Permitting and Inspections Department  
Michael A. Russell, MS, Director

CBL: 061 C018001  
Located At: 315R Spring St.

You subsequently applied for an after-the-fact HVAC permit #2017-01667 for "Installation of wood stove model Morso 1440". In connection with that permit, you expressly agreed "to conform to all applicable laws of this jurisdiction." Further, as a condition of the permit, you agreed to take responsibility for scheduling inspections for the work being done, and understood that the inspector could require modifications to the work if it did not meet code requirements.

**FIGURE 4.2(a) Chimney or Vent Termination Less Than 10 ft (3.1 m) from Ridge, Wall, or Parapet.**

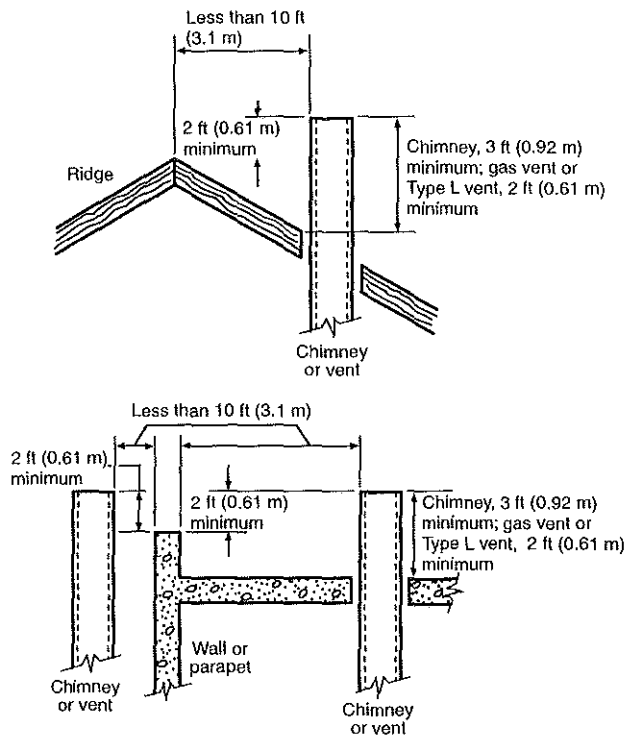
During an evaluation of the property on 12/20/17, City inspectors confirmed that the wood stove venting did not comply with NFPA 211, 2006 edition section 4.2 as adopted by the State of Maine. This property remains in violation of those requirements, and of the requirements of permit #2017-0167.

1. Immediately discontinue the use of this chimney and wood-fired appliance.
2. If you wish to resume your use of the chimney and wood-fired appliance, you must first apply for a permit to make the necessary corrections for the chimney to comply with NFPA 211, 2006 edition section 4.2, by providing for the termination of the chimney vent above roof level as illustrated in Figure 4.2(a) and Figure 4.2(b), see attached.
